**RE: Access Logistics Park, 884-928 Mamre Road, Kemps Creek – SSD 17647189
Consolidated Stakeholder Engagement & Response to Submissions**

TABLE 1 RESONSE TO TFNSW COMMEMTS (DATED 23 DECEMBER 2022)	
Agency Comment	Response
Intersection Design and Further Information Request.	
1. TfNSW requires verification that the deceleration and acceleration lanes will satisfy Austroads requirements. TfNSW Road Design team have recommended that the deceleration lane be extended to reflect the expected traffic volumes, articulated vehicle movements, road gradients and speed of travel. An additional shoulder area is also to be provided. In addition, the ultimate arrangement needs to be consistent with the local road network in Mamre Road Precinct Development Control Plan. TfNSW requires the southbound lanes to remain consistent with MRUS2 strategic design, and the deceleration lane to be included within proposed verge and developer owned land.	The LILO design plan has been amended to ensure deceleration lane satisfies Austroads Requirements. As advised, design plan has been amended and an additional shoulder area has been provided (refer to the amended design plan (2021_19_SD_0001_SK0007D Issue

**Annexure 2 – Acceleration Design (Stage 2) 2021\_19\_SD\_0001\_SK00017 Issue A**

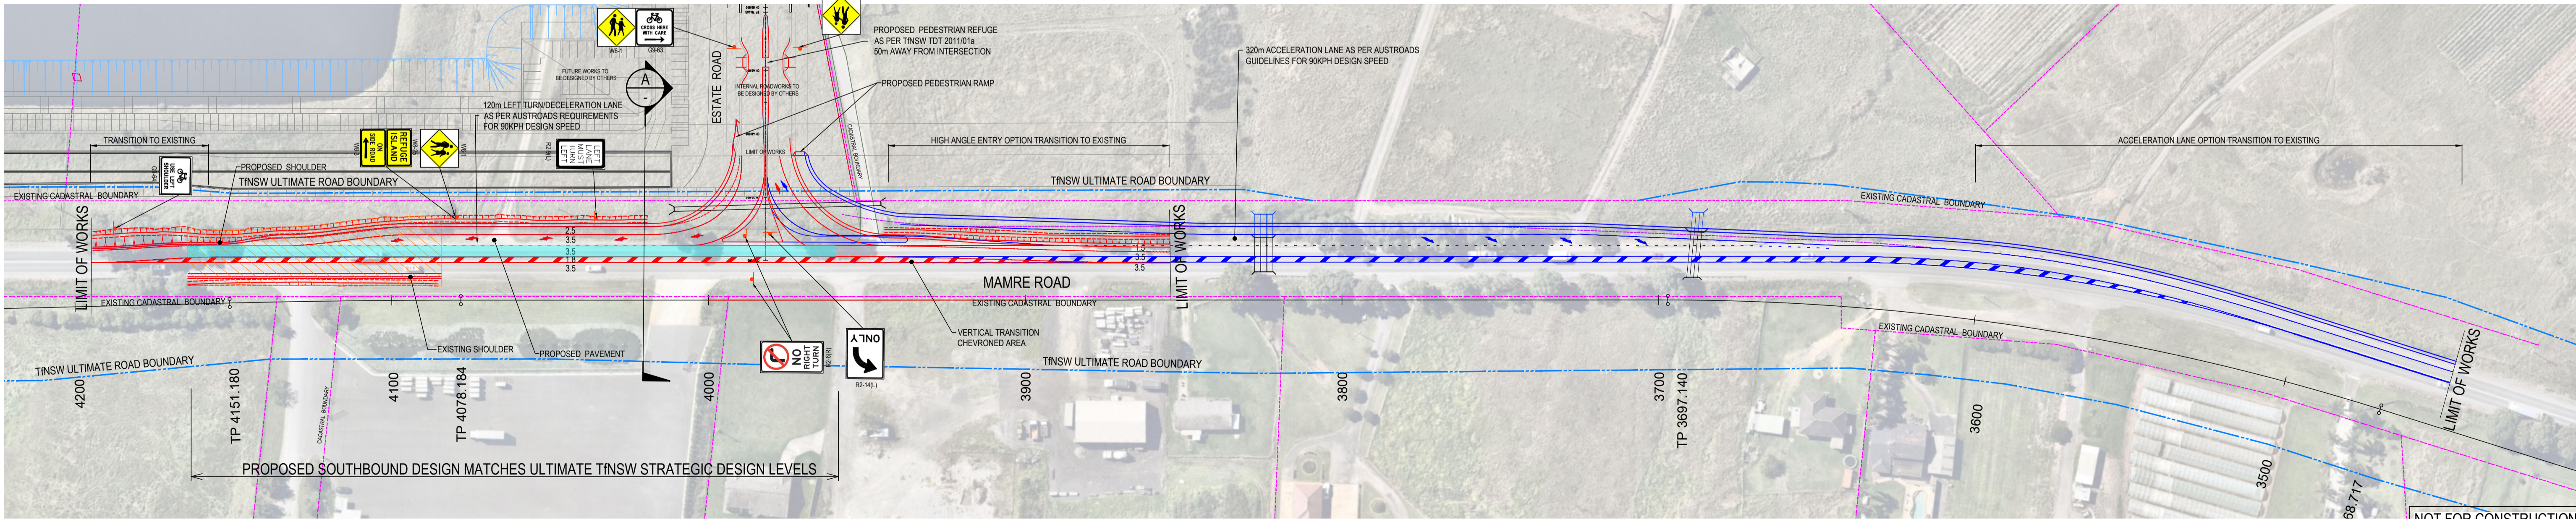
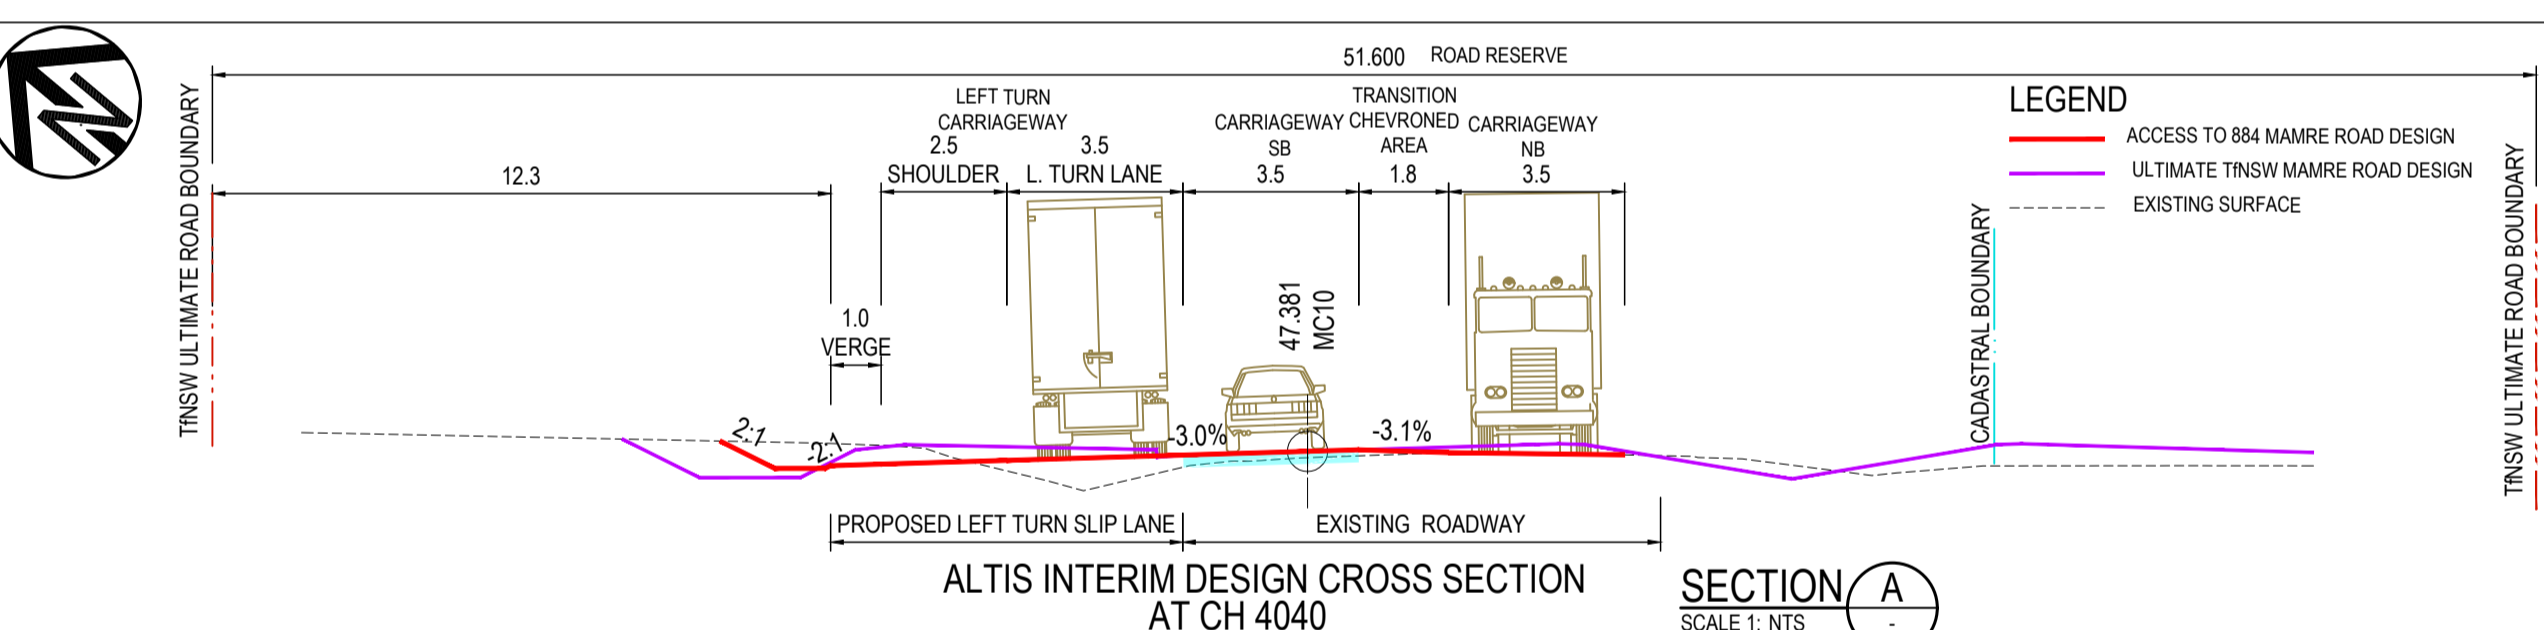
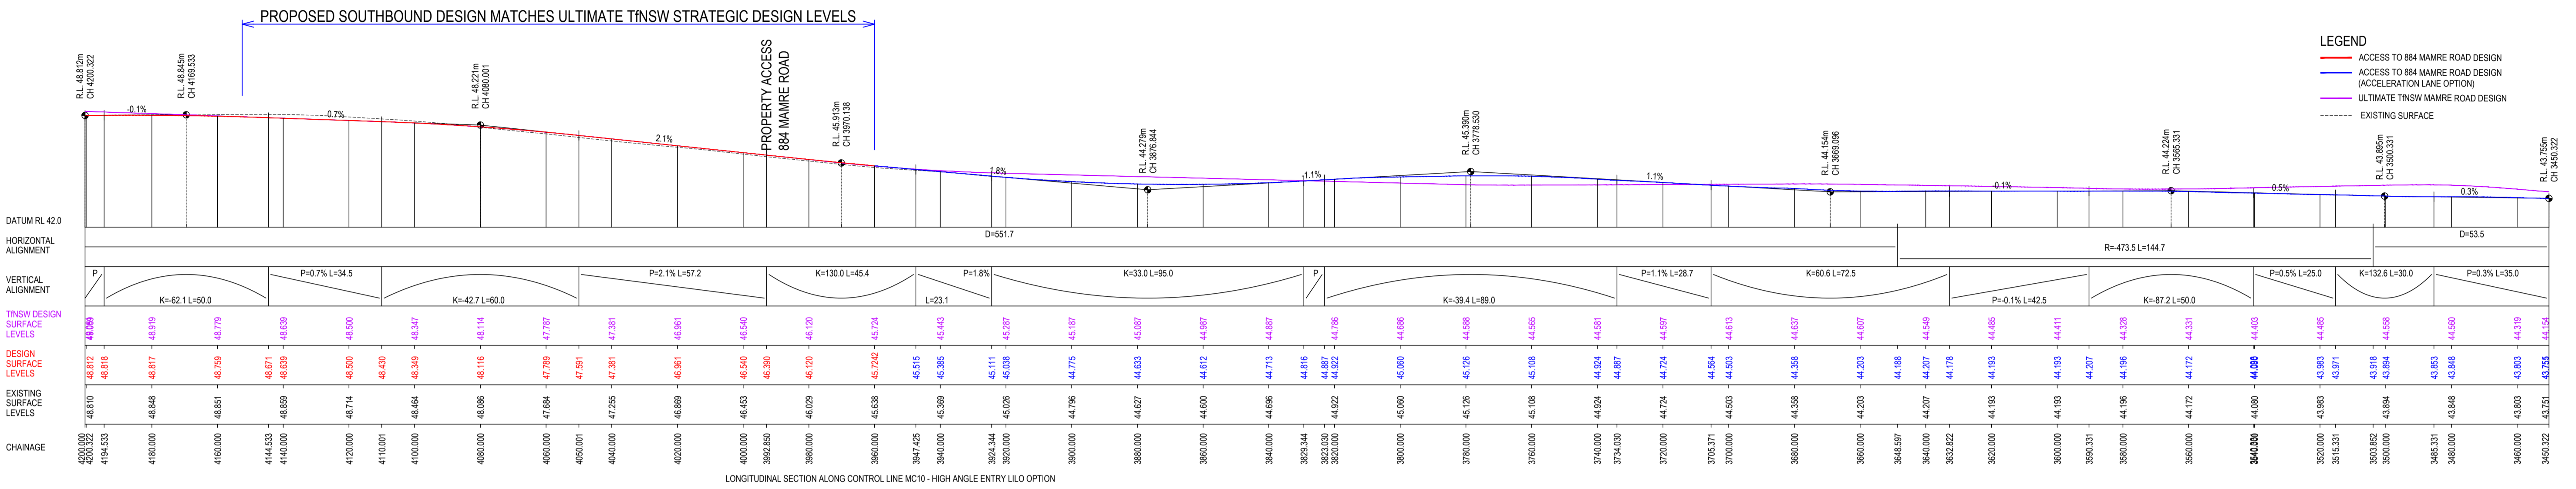
TABLE 2 RESONSE TO TFNSW COMMENTTS (DATED 10 AUGUST 2022)																																				
Agency Comment	Responses																																			
1. TfNSW does not support the acceleration lane at proposed location due to site constraints. (impacts to adjoining landowners).	MU Group notes the weaving issue at the proposed acceleration lane with vehicles entering two private property driveways and with heavy vehicles exiting the development site. It is noted that the weaving manoeuvres may conflict and create safety issues resulting in a crash. The strategic design submitted to TfNSW addresses the weaving movement by including a sign that allows local traffic to use the deceleration lane and enter a gap in the splitter median to safely enter the acceleration lane prior to entering the driveway.																																			
2. The design provided is unorthodox and there is nothing that requires a resident to use that arrangement. The cut-out in the median may also be mistaken as a refuge.	The Design (Drawing No. 2021_19_SK_0007) has now been amended to remove cut-out in the median. An alternative arrangement to avoid the weaving movement is to allow the local traffic to enter the development site and use the internal roundabout (approximately 200m within the development) for a U-turn movement and exit via the acceleration lane to access their properties. This can be developed into a Local Access Plan for the private properties. It is noted that the volume of local traffic performing this manoeuvre is anticipated to be 2-4 vehicles per day.																																			
3. The length of the acceleration lane at this location is considered too short and would not be supported on this ground	The length of acceleration lane in the strategic design is 320m, which complies with Table 5.7 of Austroads Guide to Road Design Part (AGRD) 4A. This is based on the acceleration lane length for semi-trailers to a specified decrement of 20km/h below the through lane speed of 80km/h. Table 5.7: Acceleration lane lengths (m) for semi-trailers to accelerate from rest to a specified speed on a level or downgrade

In addition, Austroads (AGRD-Part 3) states: Where possible, overtaking lanes should be located so that merge tapers are not located on curves. Where this is not possible, care should be exercised with the location design of all merging tapers to ensure that there is adequate sight distance for the approaching driver to comprehend the existence of the merge and its geometry. The termination of the auxiliary lane should be at a point where there is a sufficient sight distance of the overtaking driver to decide whether to complete or abandon the overtaking manoeuvre. It is important that the termination point provides sufficient sight distance to allow a smooth and safe merge between fast and slow vehicle streams. It is desirable for the termination point to be on a straight to give drivers a better visual appreciation of the approaching merge. Based on MU Group design experience, it is a good design practice within TfNSW to consider ending the merge taper on a straight section of road to provide the best definition of the merge and should be achieved wherever possible. Ending within a horizontal curve may still meet sight distance requirements but may not provide the same definition of where the lane is terminating. The MU Group's strategic design that includes an acceleration lane has been developed in accordance with Austroads Guide to Road Design Part 3 and 4A and complies with Austroads and TfNSW standards and requirements.
